From: [REDACTED]  
To: [REDACTED]  
Cc: [REDACTED]  
Subject: Stonehenge A303 - 15th of March 2019 - Summary of oral presentation given on 30 August 2019 (REF: 20018352)  
Date: 02 September 2019 16:36:23

As a local cyclist (and speaking on behalf of the cycling groups COGS and Cycling UK, whose representatives were not able to attend), I made the following points at the ISH on the draft DCO on 30 August 2019:

Drawing Title  
FIGURE 13.3A  
PROPOSED PUBLIC RIGHTS OF WAY

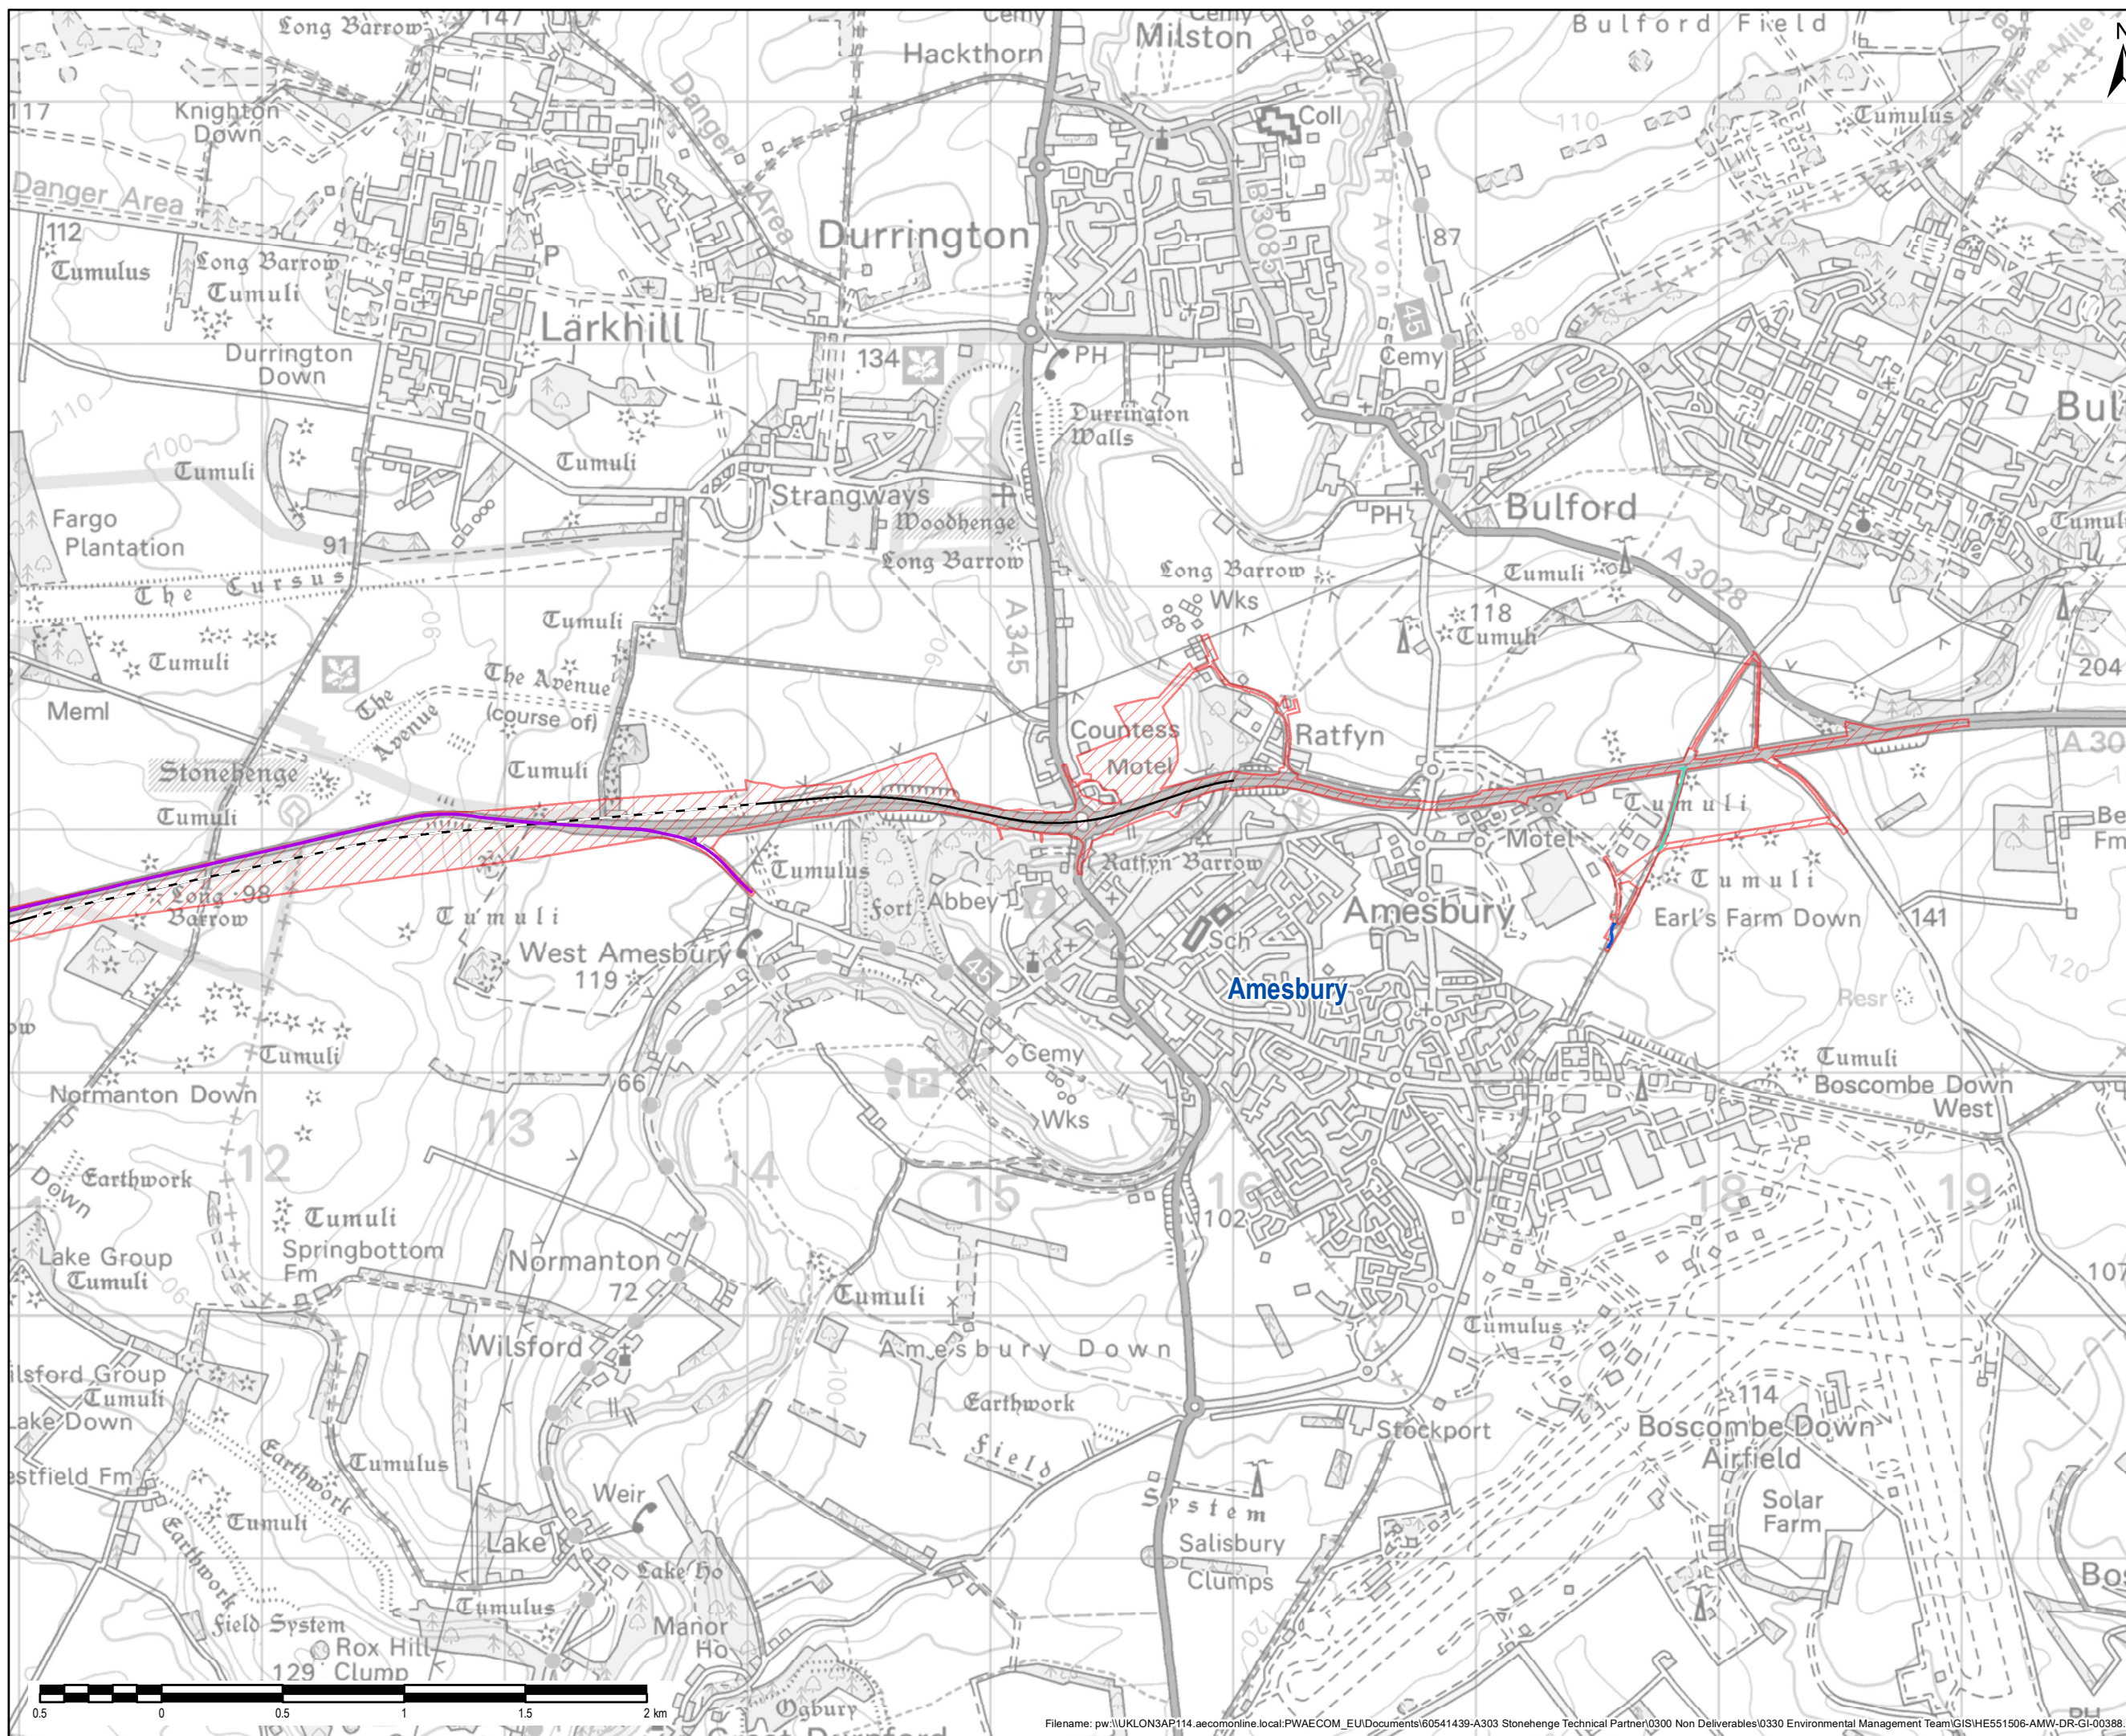
In the Outline Environmental Management Plan (OEMP) 8.47 it states that "PRow's to have a bound surface where appropriate to their use". This is too vague as cyclists of all types must have a good a surface to ride on as the existing/new roads, using routes with minimal diversion, particularly where understandably they may not on safety grounds be permitted to ride, eg through the tunnels - in any case most NMUs do not want to use the tunnels, preferring to be safely away from the dual carriageway with quiet views of the landscape and its heritage.

The OEMP also says: Surface of PRow to be agreed with adopting authority. We wish to see that the DCO/OEMP sets objectives consistent with the previous submissions made by the cycling groups/representatives, so this detail is not left to re-interpretation by others at a later stage.

Additionally, the OEMP states a maximum 3m wide bound surface: However, where possible, eg the new restricted Stonehenge Hwyway on the alignment of A303, we seek 4m out of the 8-10m available to allow for some degree of vegetation encroachment whilst leaving adequate width to avoid any user conflict, and permit shared use by statutory utility vehicles and those with private means of access, yet still leaving room for cyclists to pass a vehicle whilst remaining on the bound surface.

Further, for all new PRow's, there should be a commitment on drainage to minimise damage, reduce the ongoing maintenance burden, prevent flooding/ponding and to minimise risk from ice in winter (as manageable adverse effects on all NMUs, but especially cyclists), not least to take account of the greater likelihood of more extreme weather events as a result of climate change.

Finally, the DCO/OEMP should cover PRow road crossing points, and specifically where and what type of traffic controlled crossings are to be provided (eg Pegasus, essential at Longbarrow) to minimise severance for all NMUs, especially as traffic flows are likely to increase over time?
